**Consultation Response from KC,
Ecology Unit**

2020/92331 Land east of, Leeds Road, Chidswell, Shaw Cross, Dewsbury

**Date Responded:
08/09/2020**

Figure 2 Pre-development habitats.

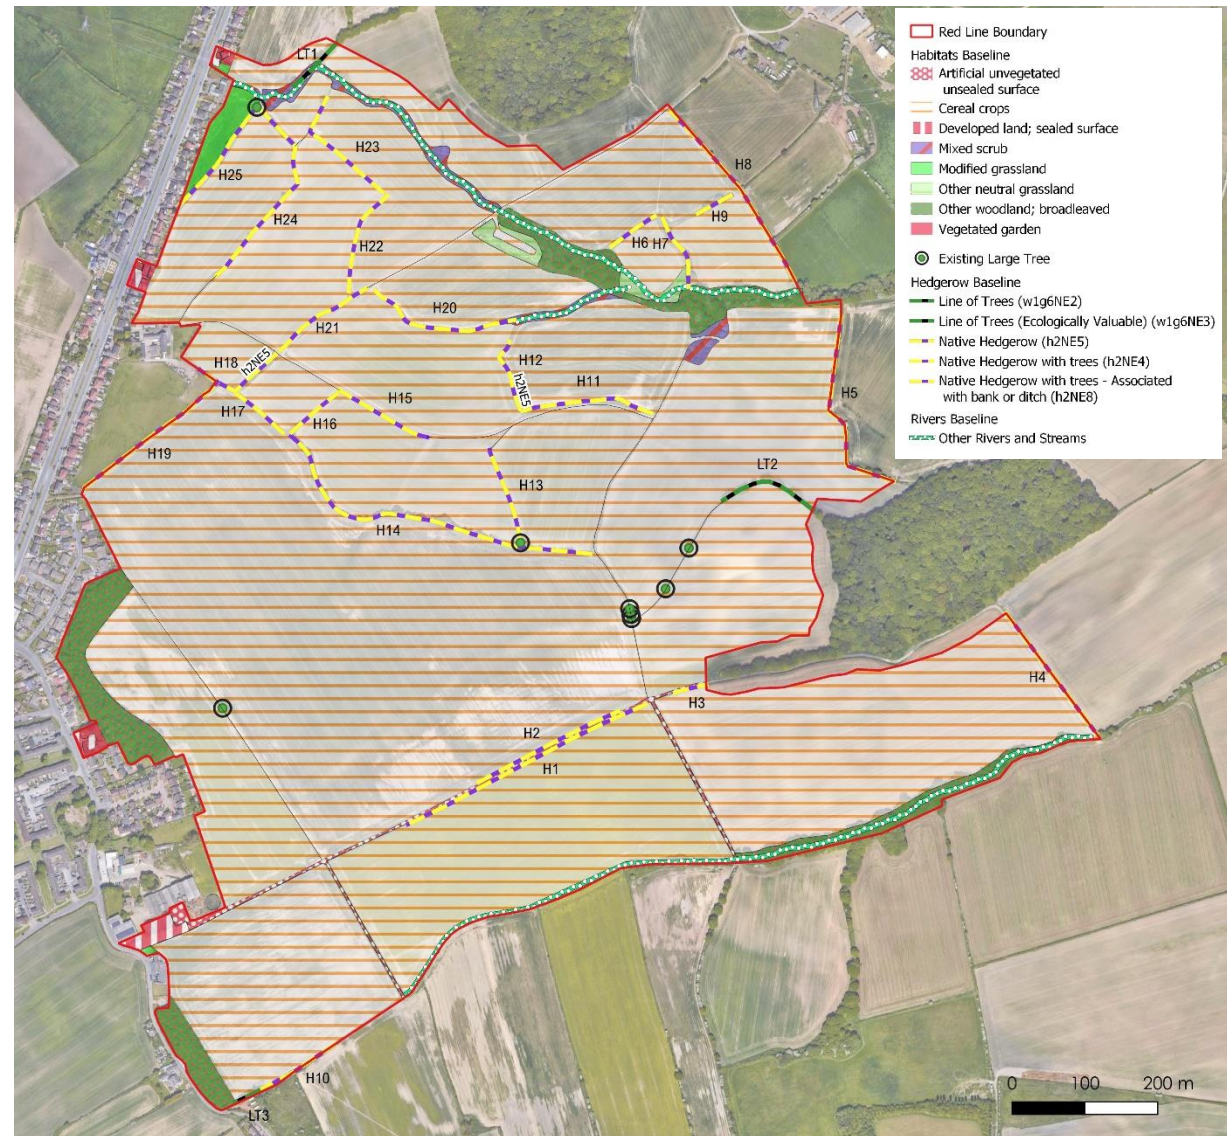
There are a number of changes needed to the Biodiversity Metric calculation as highlighted at pre-app and by Yorkshire Wildlife Trust. These changes should be made, and the development reassessed for the percentage loss/gain in biodiversity post-development. As the current gain is 3%, which is potentially reduced with the requested changes, the proposals should be revisited to demonstrate that a 10% net gain in biodiversity can be achieved post-development.

Information is also required to demonstrate that the development can achieve a biodiversity net gain in accordance with Local Plan Policy LP30 (ii). This should include changes to the biodiversity metric calculations as specified and evidence that the proposed development can achieve a 10% net gain in biodiversity post-development.

Figure 4 Post-development habitats.

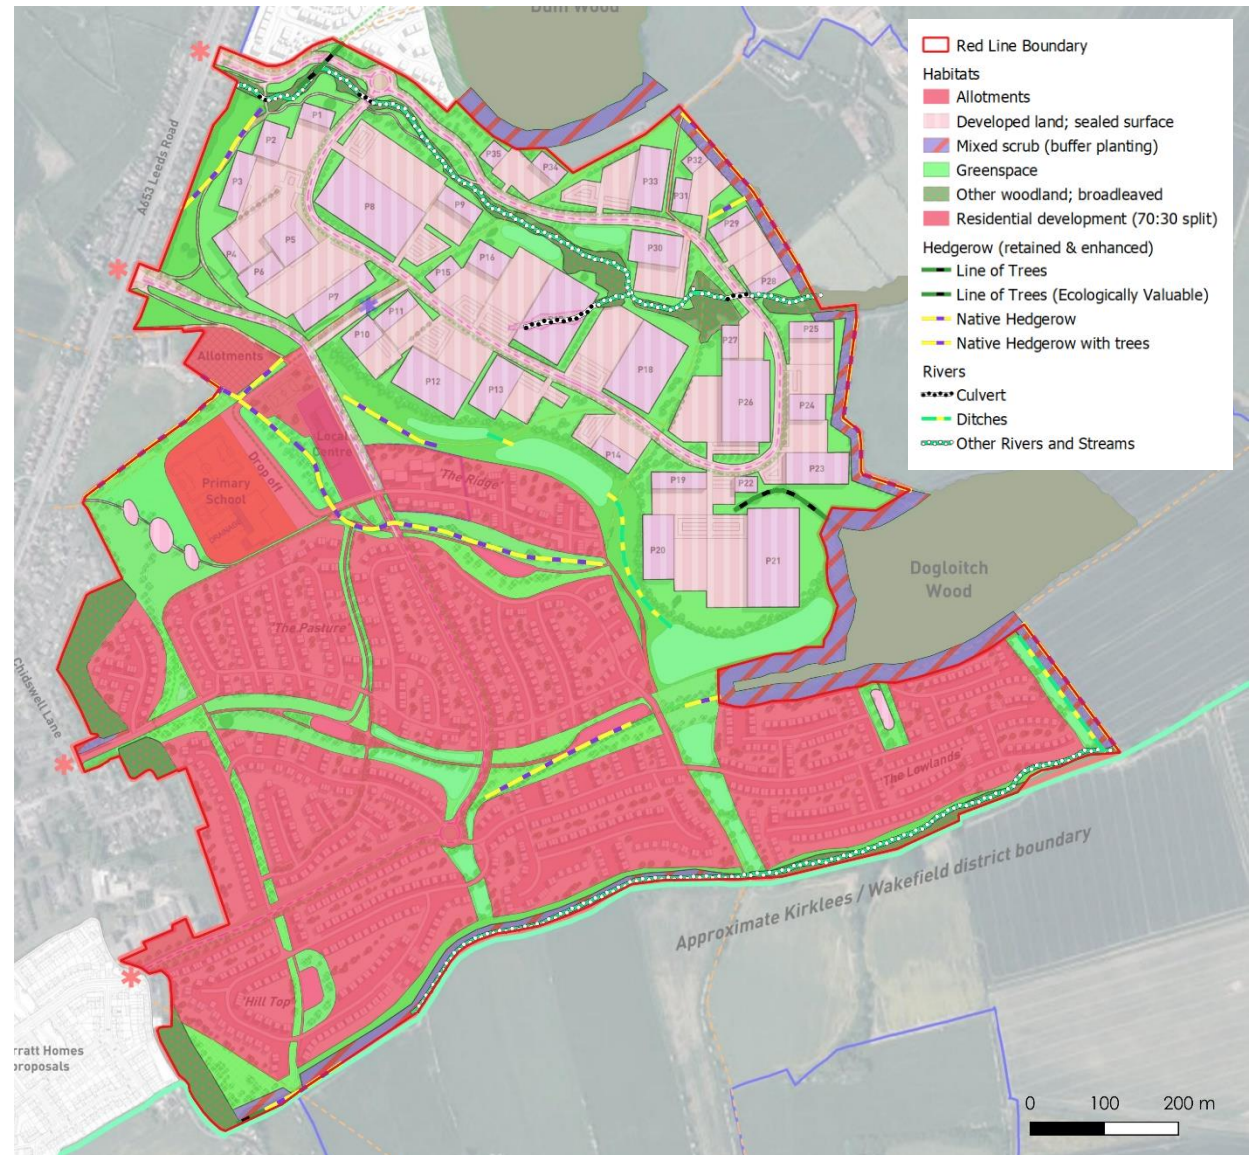
The current green infrastructure plans indicate that much of the Kirklees Wildlife Habitat network (KWHN) will be retained post-development, with the inclusion of a link between Dum Wood and Dogloitch Wood, which is welcomed. However, the site currently supports a network of hedgerows and linear features which provide connectivity in a grid like formation over the site. Local Plan policy PLP 30 requires developments to "*safeguard and enhance the function of the KWHN and to establish ecological links to the network, where opportunities exist.*" In this case there are opportunities for enhancement and of establishing links. I am supportive of the principle of maintaining many of the existing hedgerows and creating new hedgerows, as shown in the proposed masterplan, to maintain this function. Ecological corridors and SuDS should be the main focus of the habitat creation that is required as mitigation.
